COLORADO GEOLOGICAL SURVEY

**Subject: Falcon Marketplace Preliminary Plan (File Number SP-17-001)
Falcon Peyton comprehensive plan, El Paso County, CO; CGS Unique No. EP-17-0031_2**

Colorado Geological Survey has reviewed the response to comments for the Falcon Marketplace Preliminary Plan referral. We understand the applicant proposes 11 commercial lots and a regional detention facility on 36.4 acres located northwest of the intersection of Woodmen Road and Meridian Road. With this resubmittal we received, a Request for Review #2 (El Paso County, March 23, 2017), a Letter of Intent and Preliminary Plan (Drexell, Barrell & Co, March 23, 2017), and a Response 1 letter (Drexell, Barrell & Co, March 23, 2017).

**SUB-REGIONAL POND #1 (SR4)**

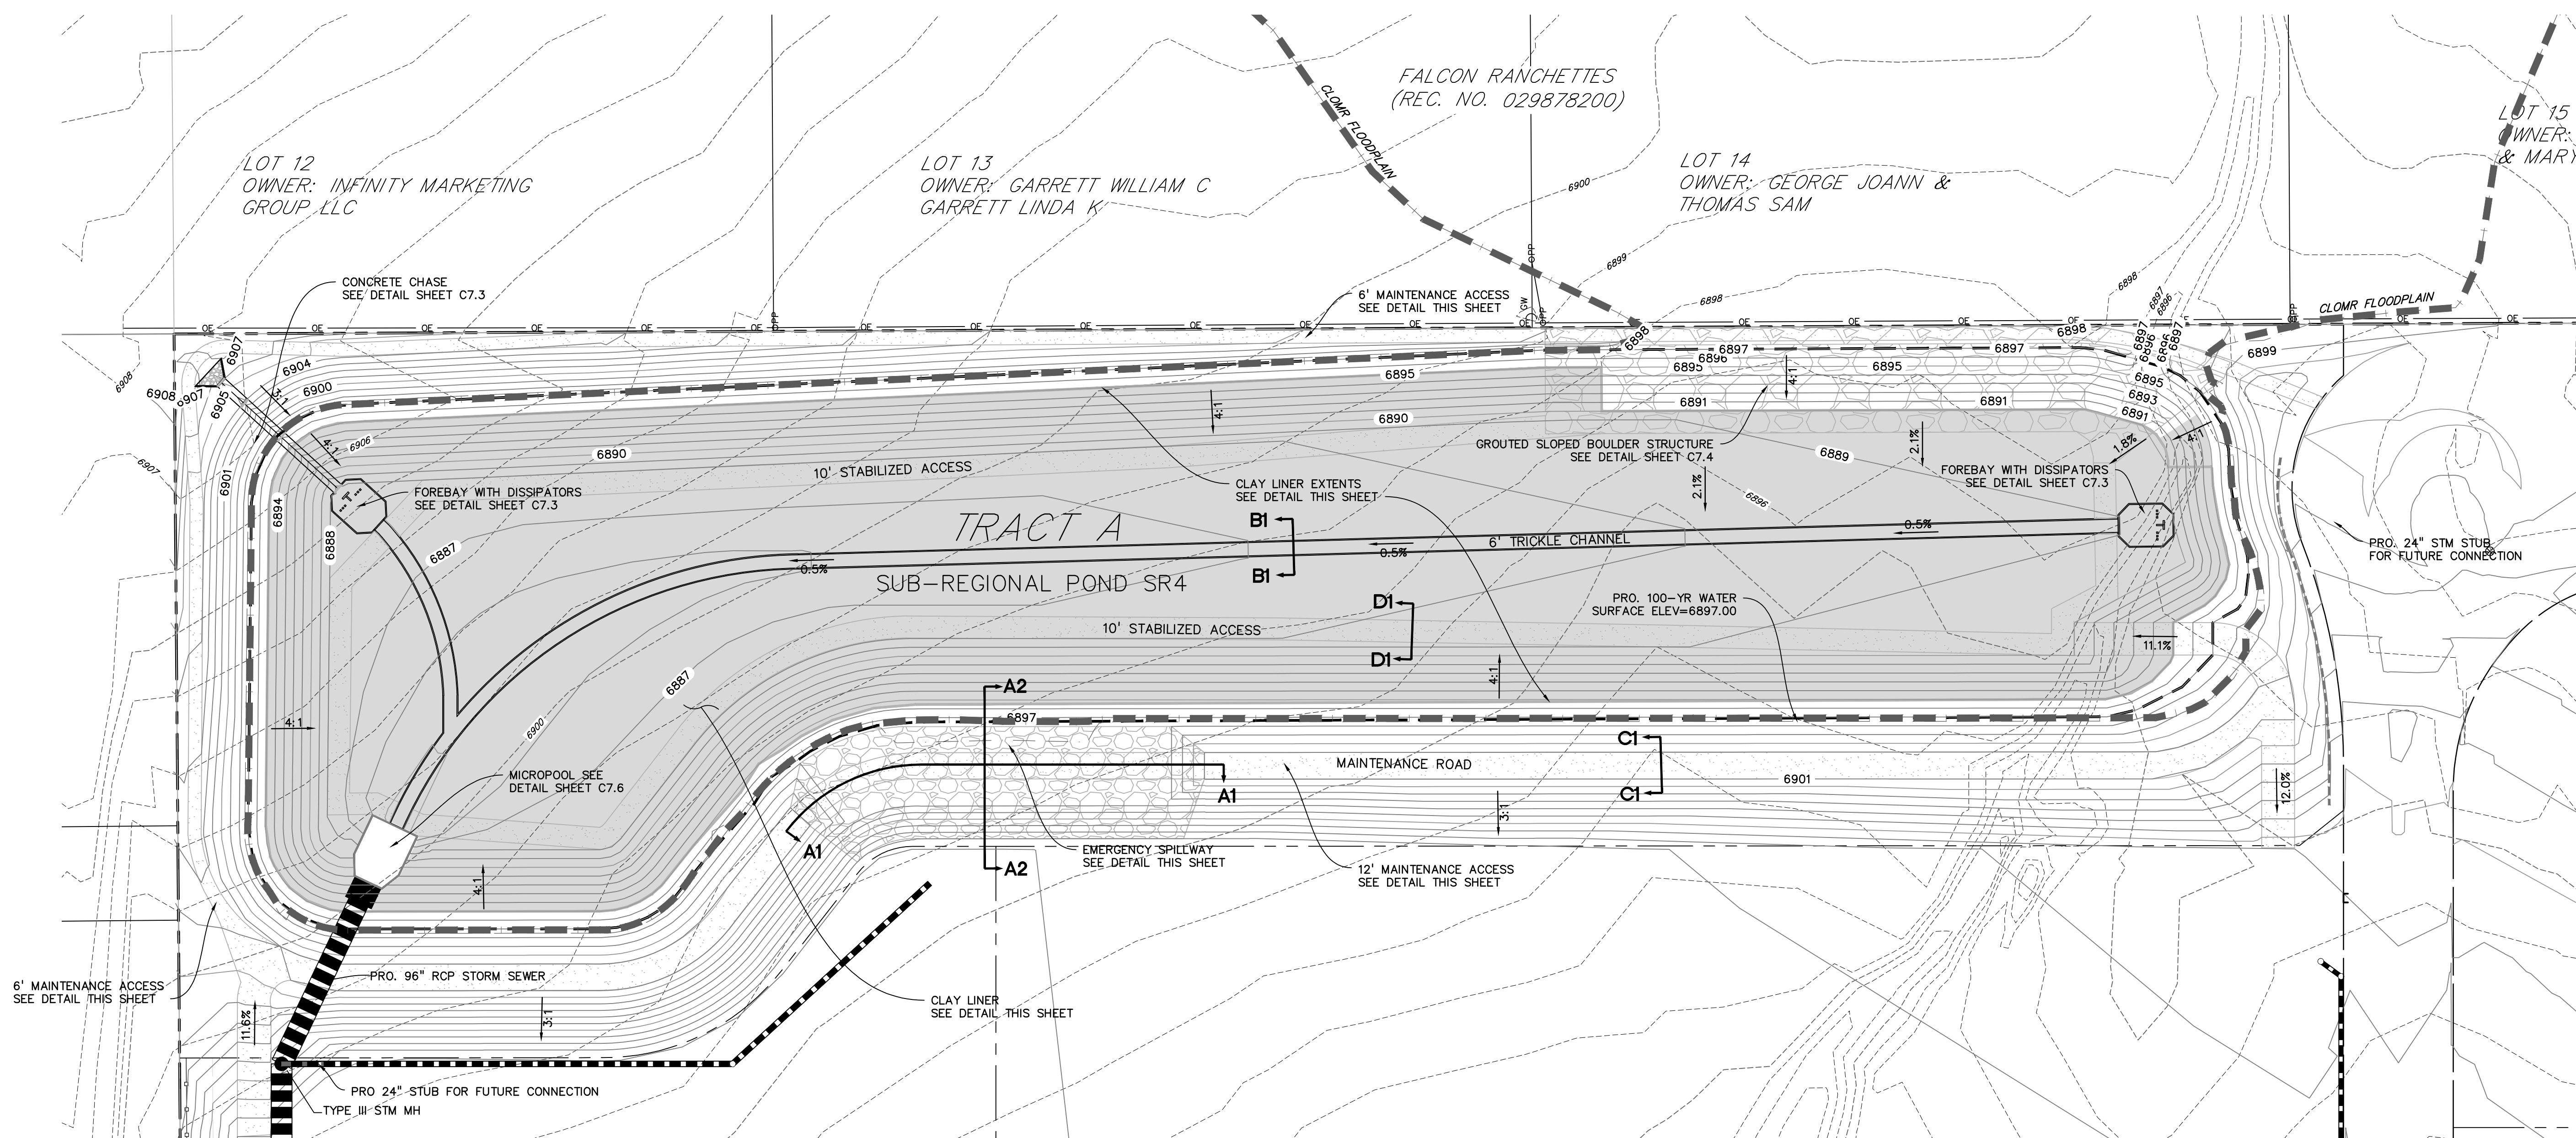
The majority of the concerns noted in our letter dated February 9, 2017 have been acknowledged in the applicant's response letter. However, the letter also indicates that the recommendation for a low permeability liner for the sub-regional detention pond #1 and the drainage provisions for storm sewer lines *"is subject to change due to the depth of groundwater in the pond area and forthcoming additional geotechnical borings in the area."* It is unclear from documents submitted how depth to groundwater or additional geotechnical borings will change the fact expressed by the geotechnical engineer that *"...detention ponds can become locations of enhanced and concentrated infiltration into the subsurface"*. This identified condition combined with an upgradient detention pond can lead *"...to wetting of foundation soils in the vicinity with consequent heave or settlement."* To mitigate this condition, as well as infiltration from storm sewer lines, the geotechnical engineer recommends a low-permeability liner for the detention pond and cut-off walls and/or drainage provisions for the storm sewer lines.

As stated in our previous letter, *"the recommendation for a low permeability liner for the sub-regional detention pond #1 (now shown as sub-regional pond SR4) and the drainage provisions for storm sewer lines must be followed. These recommendations should be indicated in the drainage report and shown on the preliminary drawings prepared for this project"*.

Provided the concerns acknowledged in Response Letter 1 are addressed, and Grounds recommendations for a low permeability liner, and cut-off walls and/or drainage provisions for storm sewer lines flowing to the pond are strictly adhered to, CGS has no objection to approval of the Preliminary Plan as proposed.
